11. **Project# 1009840**
15DRB-70476 MINOR - FINAL PLAT
APPROVAL

**April 15, 2015
DRB Comments**

PROJECT # 1010437

RE: Lots 1-6, Block 1, Mankato Place

A.L.T.A./A.C.S.M. LAND TITLE SURVEY OF  
**LOTS 1 THRU 6, BLOCK 1**  
**MANKATO PLACE**  
 CITY OF ALBUQUERQUE  
 BERNALILLO COUNTY, NEW MEXICO  
 JANUARY, 2015

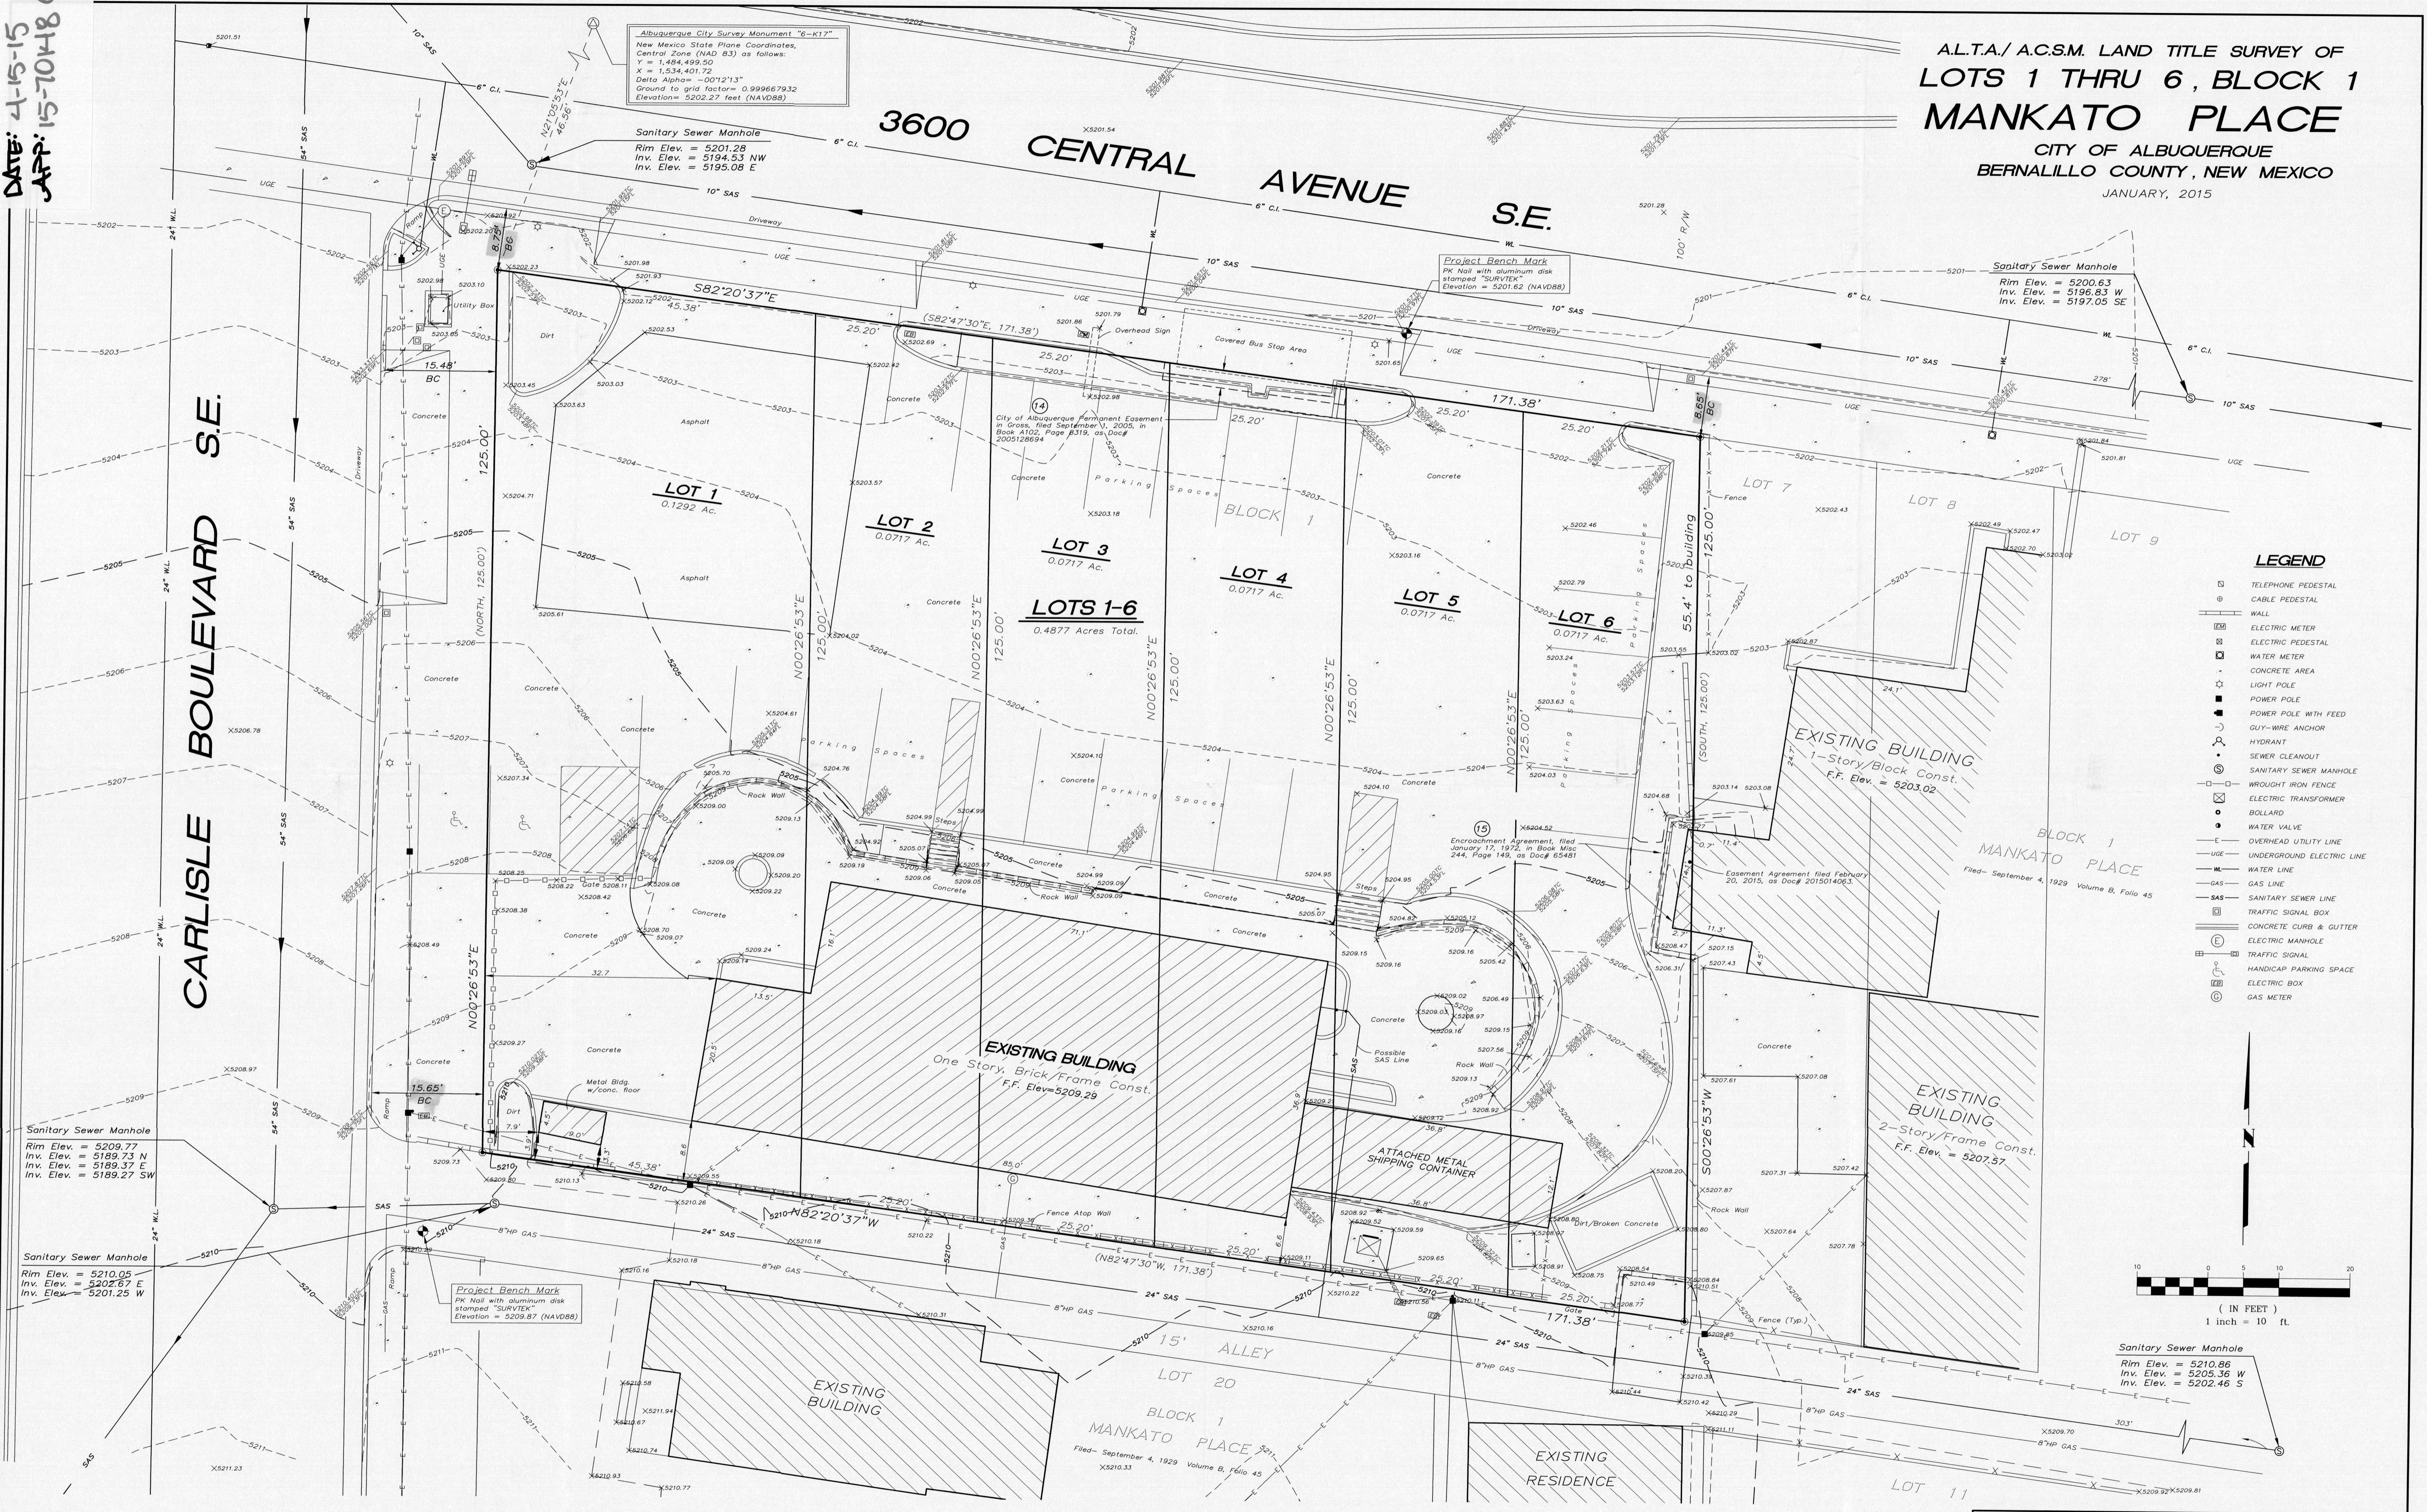
An Easement Agreement regarding building encroachment is not adequate for platting; the property to the east either needs to be involved with the plat or the owner of that property will have to modify their building such that it conforms to the Building Code.

2' foot Vacation of existing Public Alley per
15DRB-70405. (Cross Hatched Area-0.0079 Ac.)
Easement rights for public utilities to be retained. A
2' Public Access Easement over the vacated 2' foot
portion is hereby reserved.

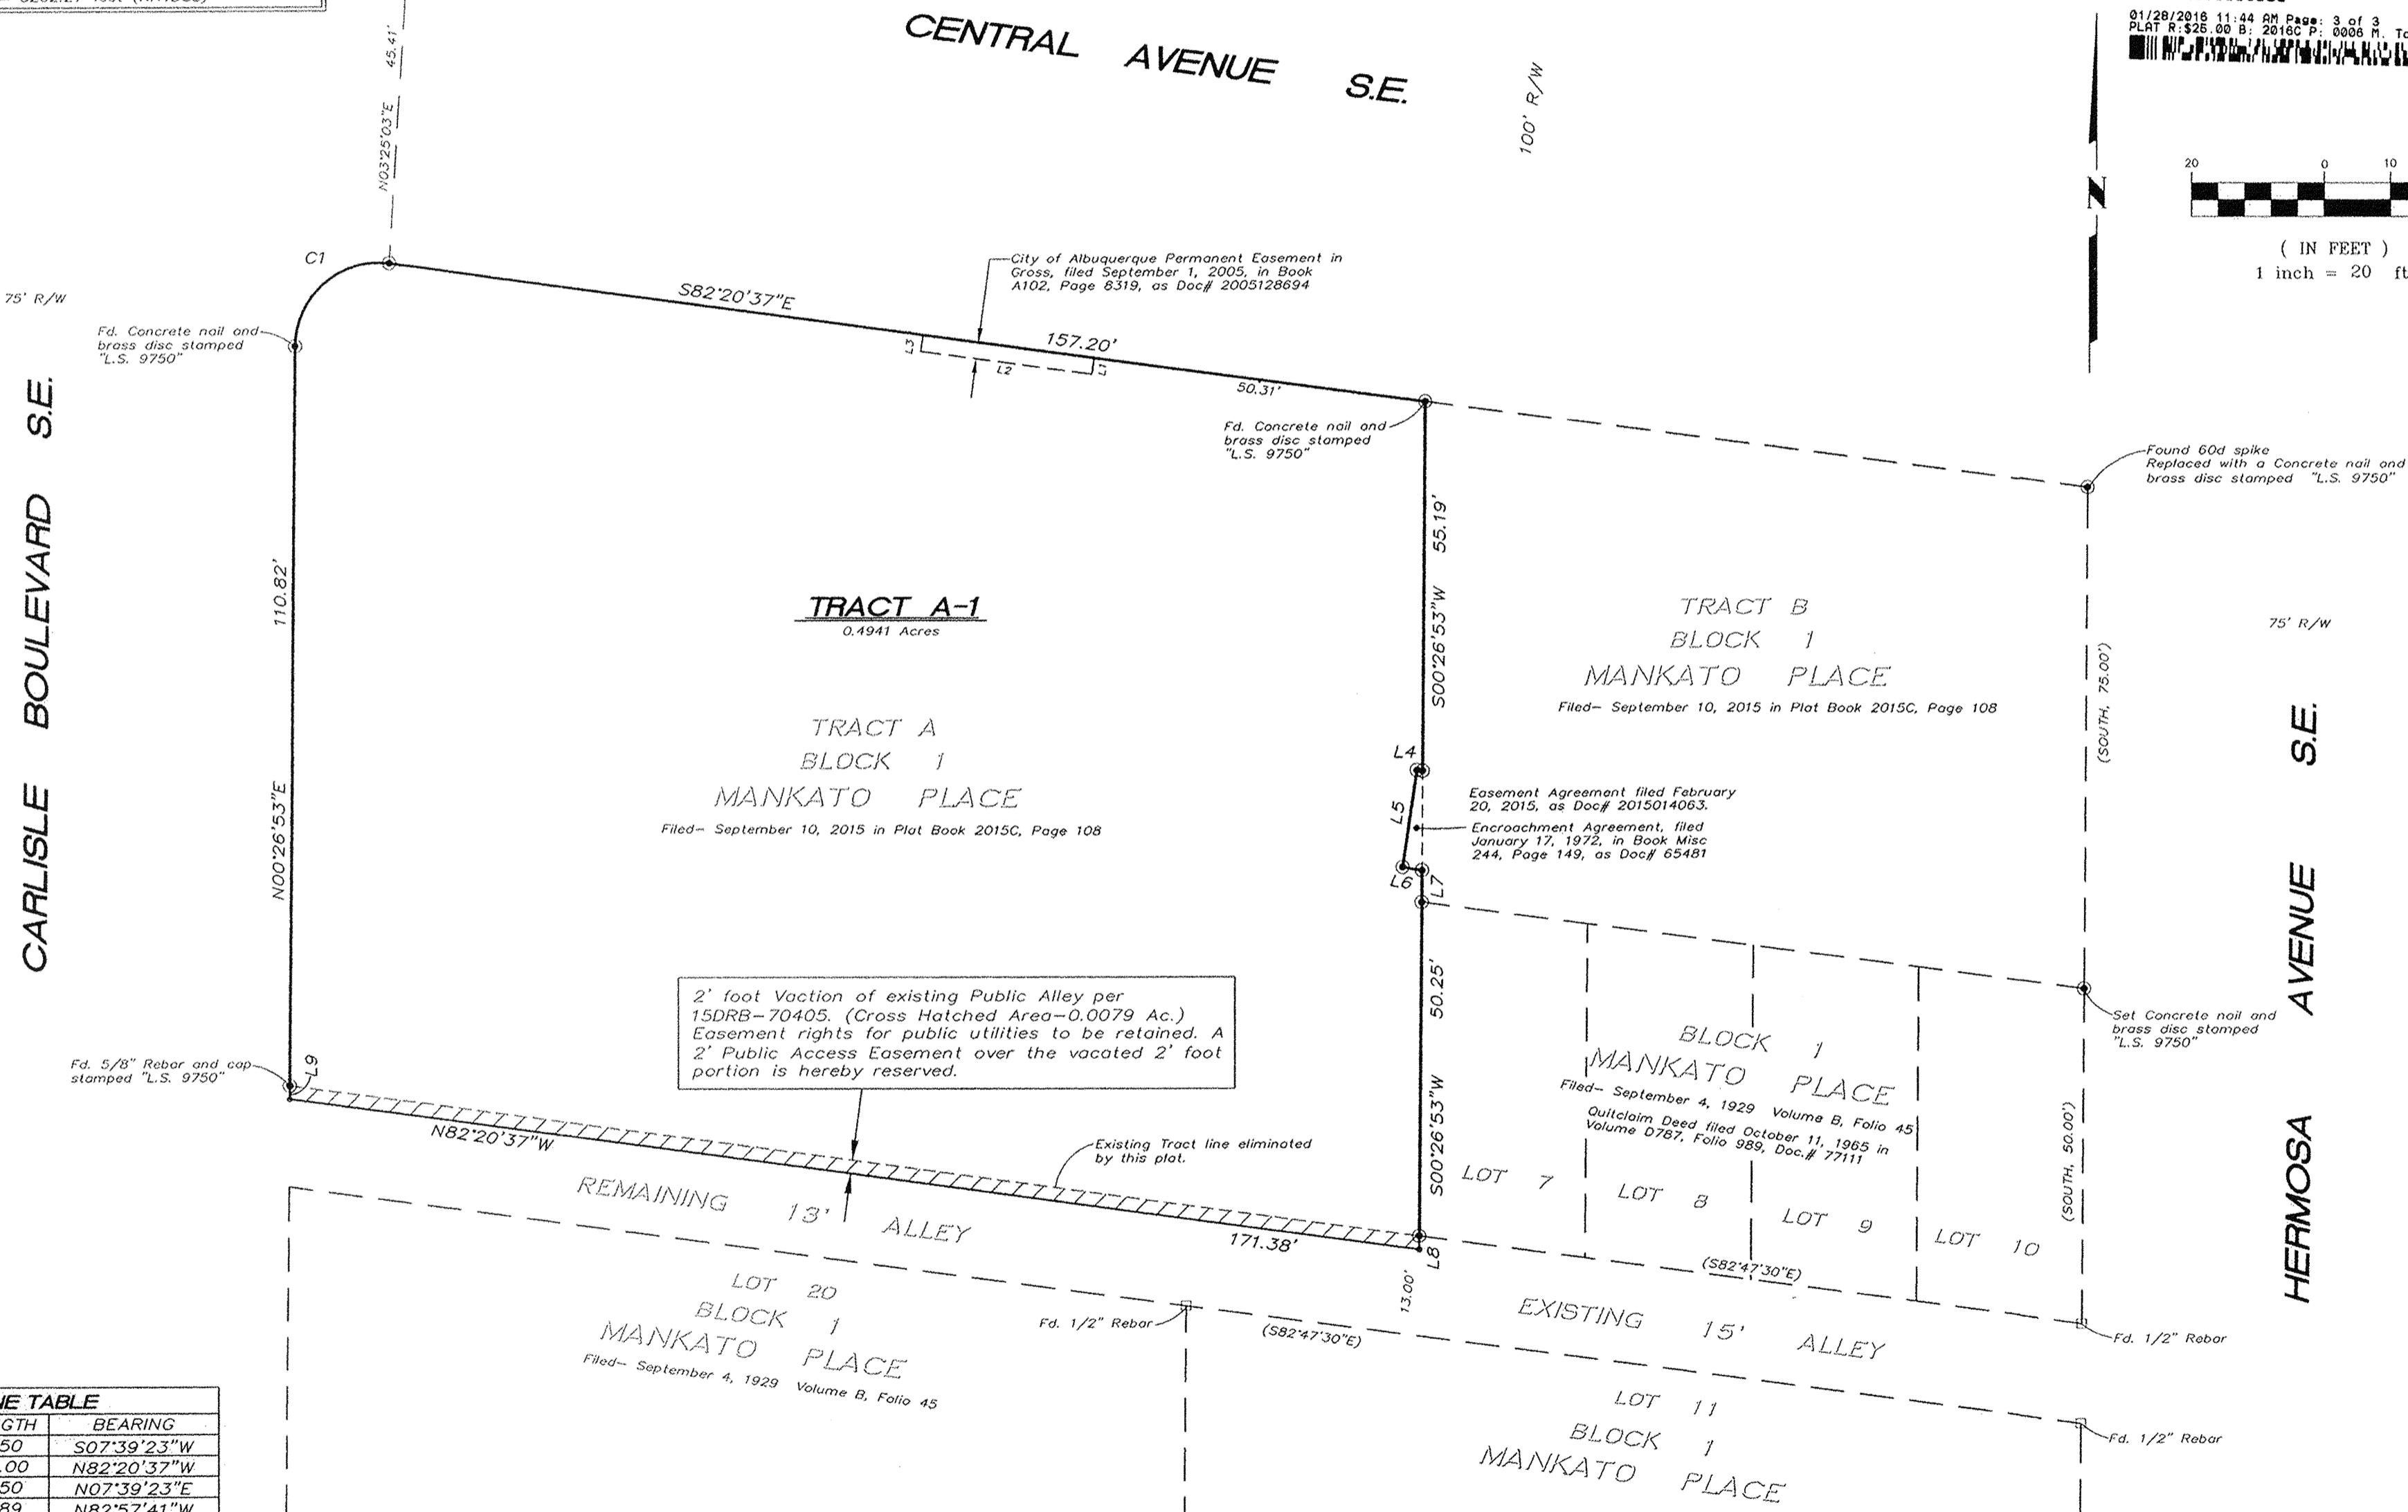
At the December 2, 2015 Development Review Board meeting, the vacation was approved as shown on exhibit b in the planning file per section 14-14-7-2(a) (1) and (b) (1)(3) of the subdivision ordinance with the condition of adequate separation of Albuquerque/Bernalillo county sewer line.

1. Final disposition shall be through the City Real Estate Office
2. The vacated property shall be shown on a replat approved by the Development Review Board and the approved replat shall be filed for record with the Bernalillo County Clerk's Office within one year.
3. An easement or sewerline relocation satisfactory to the ABCWUA will be required.
